Subject: FAO Case Officer Brenda Louisy-Johnson: Highways England HOLDING RECOMMENDATION (our ref 91812#13712 re application AL/87/21/PL Oldlands Farm Newlands Road Bognor Regis PO22 9FJ)

**Developments Affecting Trunk Roads and Special Roads
Highways England Planning Response (HEHR 2021)
Holding Recommendation in connection with an
Application for Planning Permission**

Council's Reference: AL/87/21/PL

Proposal: Erection of a warehouse (Use Class B8) with ancillary office, associated vehicle parking, van storage, plant, ancillary structures, lighting landscaping and infrastructure works including earthworks to facilitate flood compensation area. This site may affect listed buildings, may affect the character & appearance of the Shripney Conservation Area, is a Departure from the Development Plan, affects a Right of way & is in CIL Zone SP3 (Zero Rated) as other development.

7.0 LAYOUT

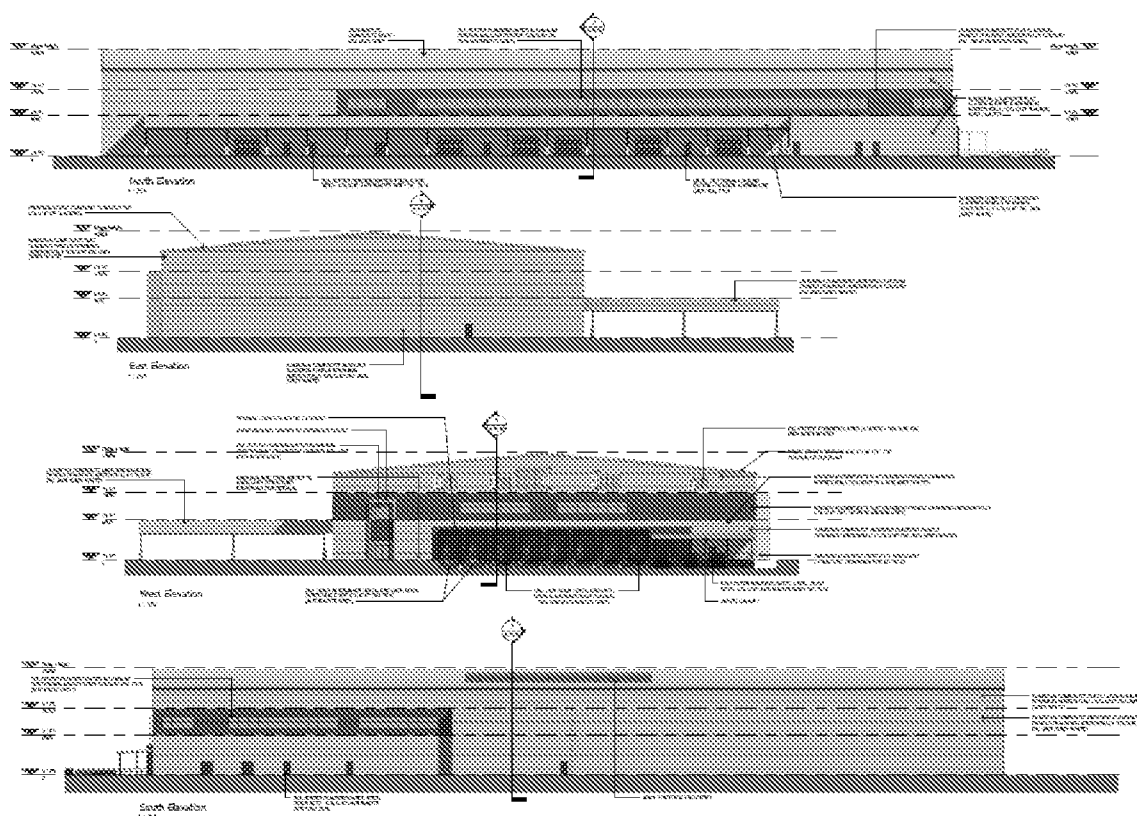
It is noted that a total of 193 car parking spaces are proposed to be provided at the site for employees and visitors, including 9 disabled parking spaces. This is significantly more than the 114 spaces which would typically be provided in line with West Sussex County Council and Arun District Council's adopted parking standards. The amount of car parking is considered to be necessary by the applicant in order to enable shift changeovers to happen at the site and is stated to be based around the requirements known to be associated with a similar site in use by a potential operator of the proposed development; information from this potential operator has also been supplied to inform the trip generation exercises.

In addition, the applicant is proposing 512 van spaces and 6 HGV spaces.

It is noted that the specific details of shift times and working patterns (and corresponding staff numbers) on which these requirements are based has not been included in the TA. Given that the parking spaces far exceed any normal B8 type usage, it is therefore requested that this information should be provided to Highways England in order that the actual number of proposed car parking spaces can be tested against this requirement.

Action: Applicant to provide details of expected shift patterns and corresponding staff requirements to Highways England.
